**WALLARAH 2 COAL PROJECT  
WYONG SHIRE COUNCIL LATE SUBMISSION - RESPONSE**

Wyong Shire Council (WSC) has subsequently provided a further comment following closure of the exhibition period dated November 2013 (see **Appendix A**). This letter report responds to the issues raised in the WSC comments of November 2013.

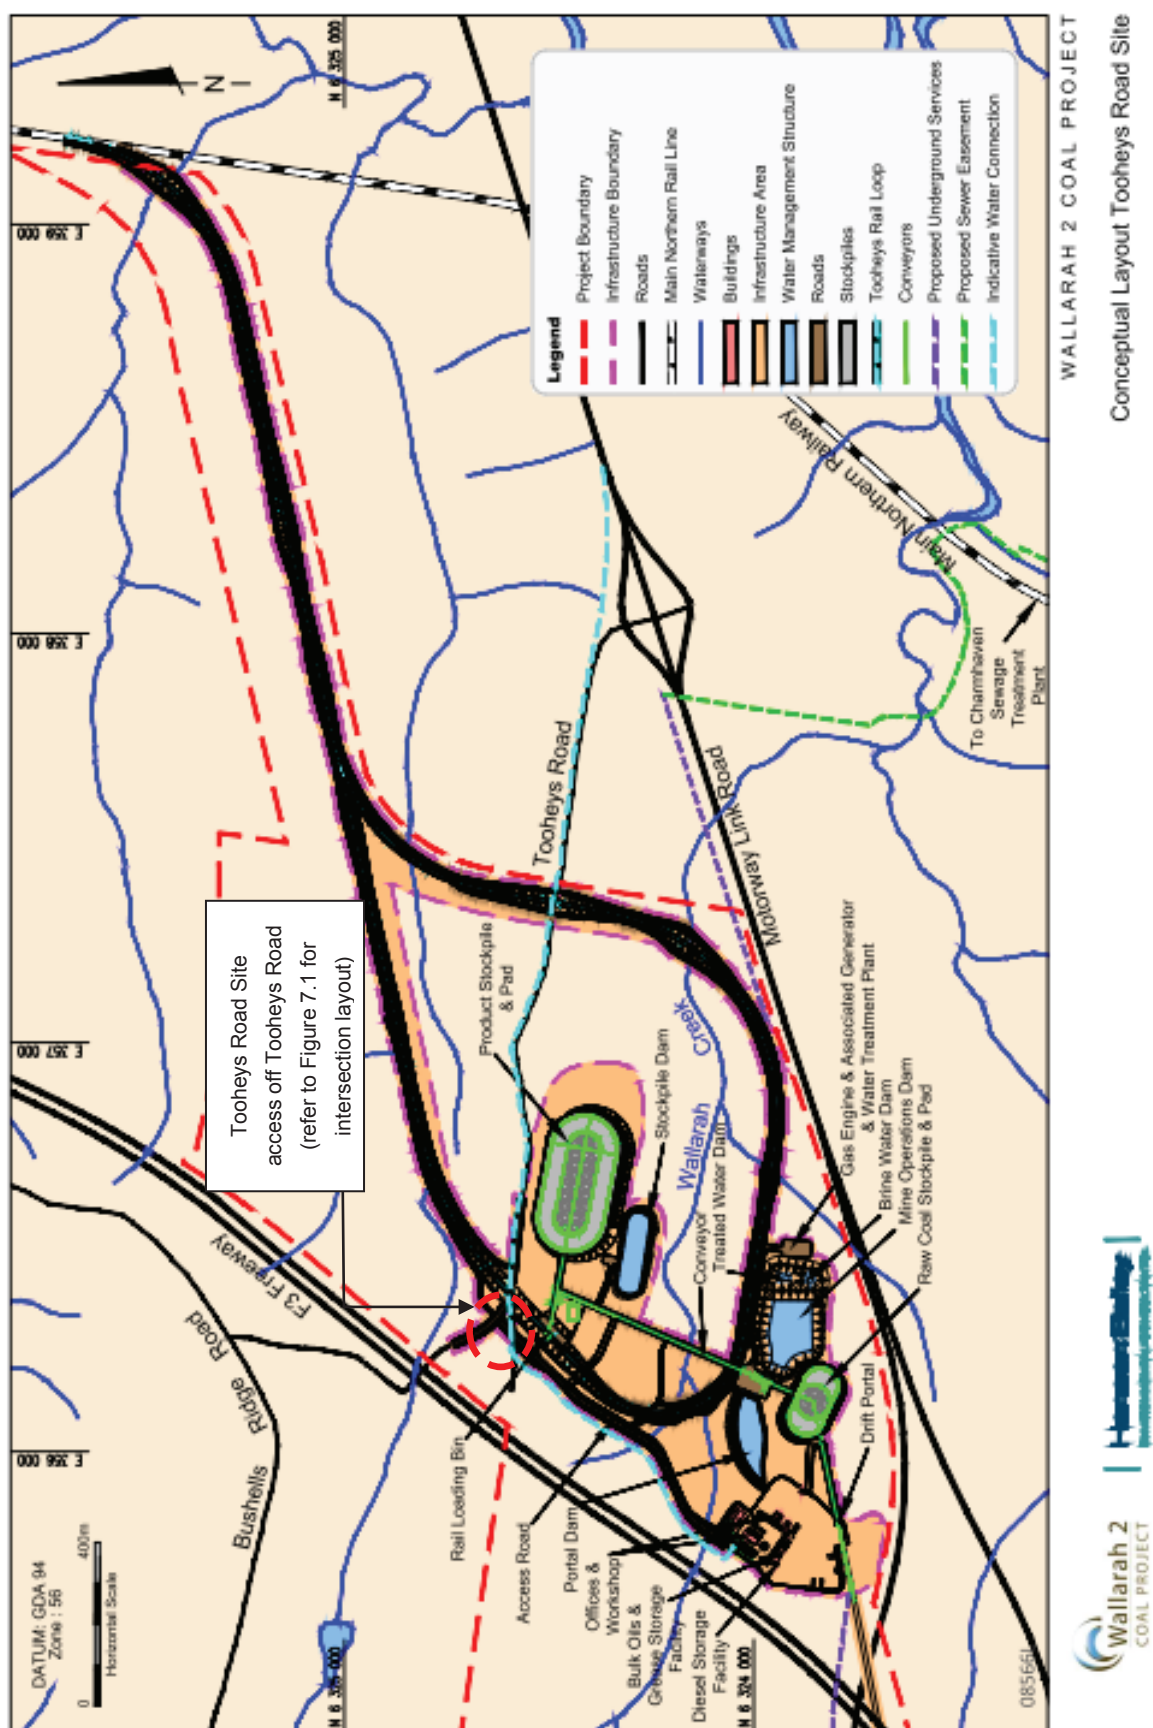
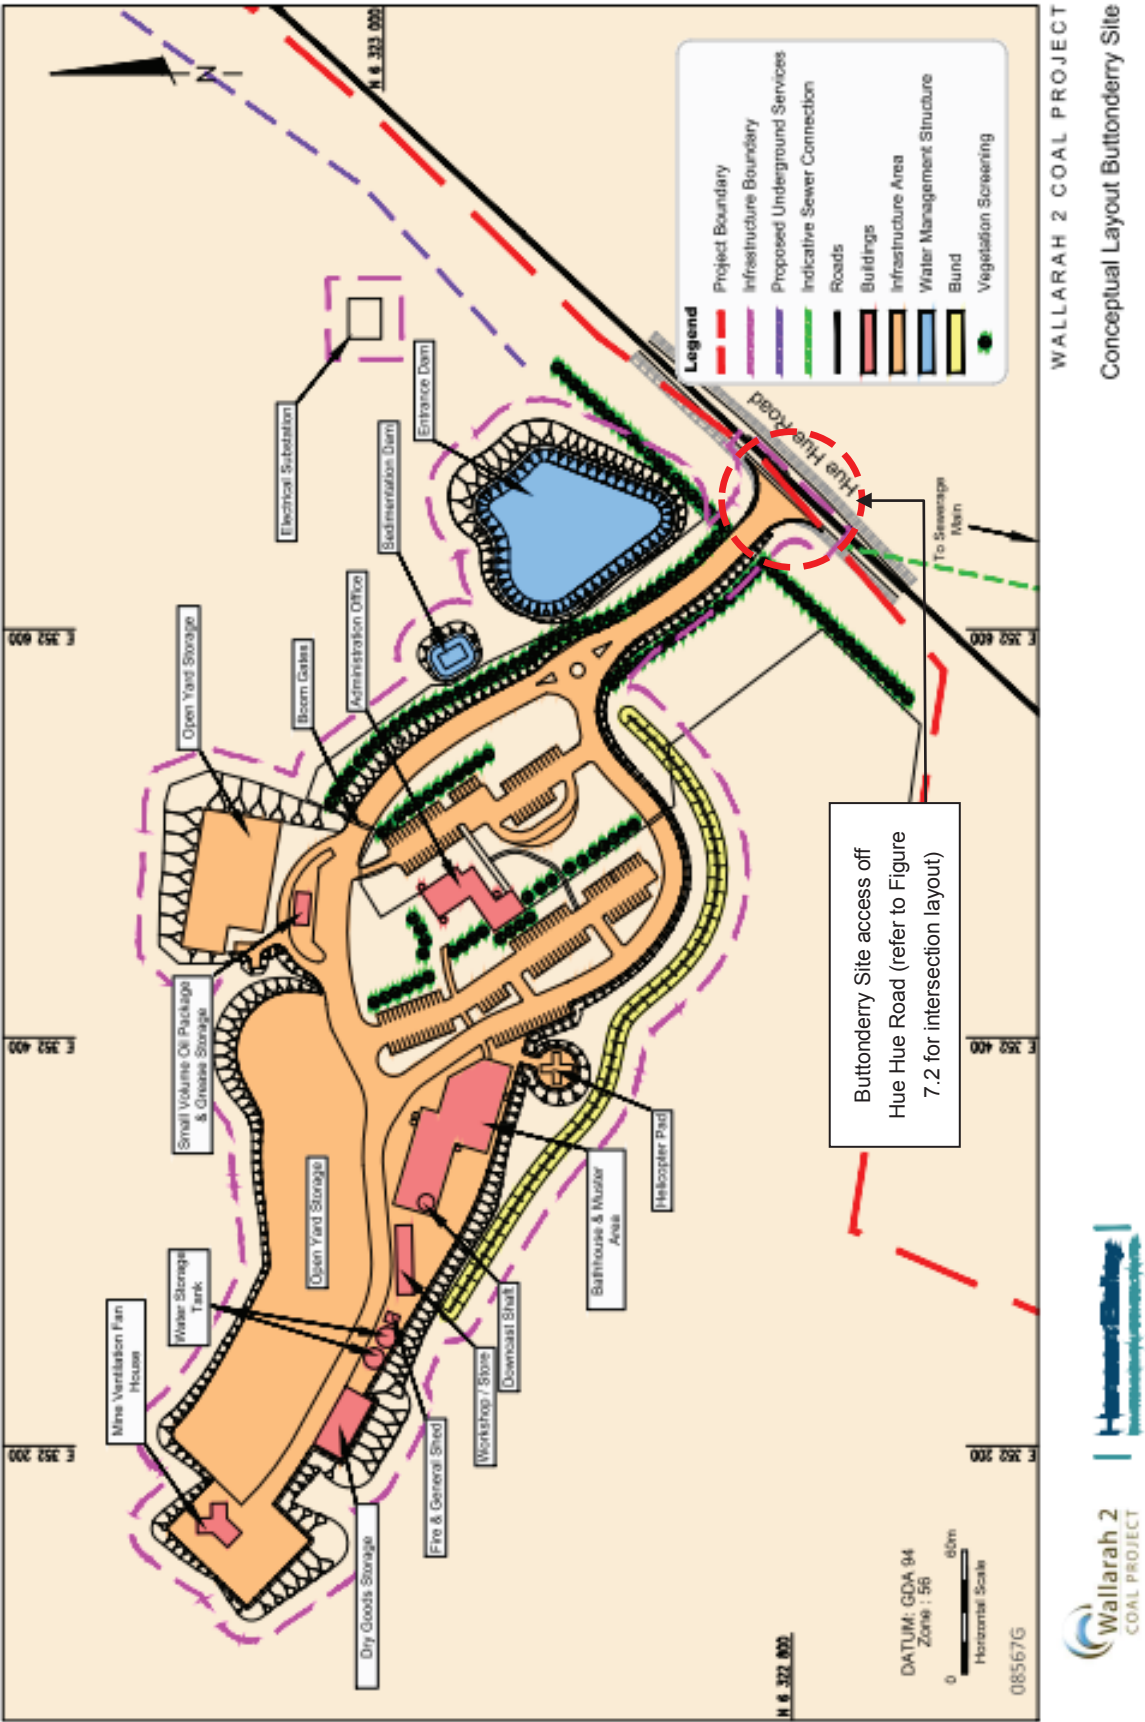
*Although little heavy vehicle movement is expected on internal roads, it is still necessary to determine potential disturbances or impacts caused by heavy vehicles on local environment (e.g. dust, noise, vibration).*

As the Project is proposed to comprise an underground mine, very limited heavy vehicle movements within the mine will occur, primarily in relation to deliveries to site from external roads. Internal roads are shown on Figure 19 and Figure 21 of the EIS for each of the Tooheys Road and Buttonderry sites, respectively. There are no heavy vehicles hauling materials within the site.
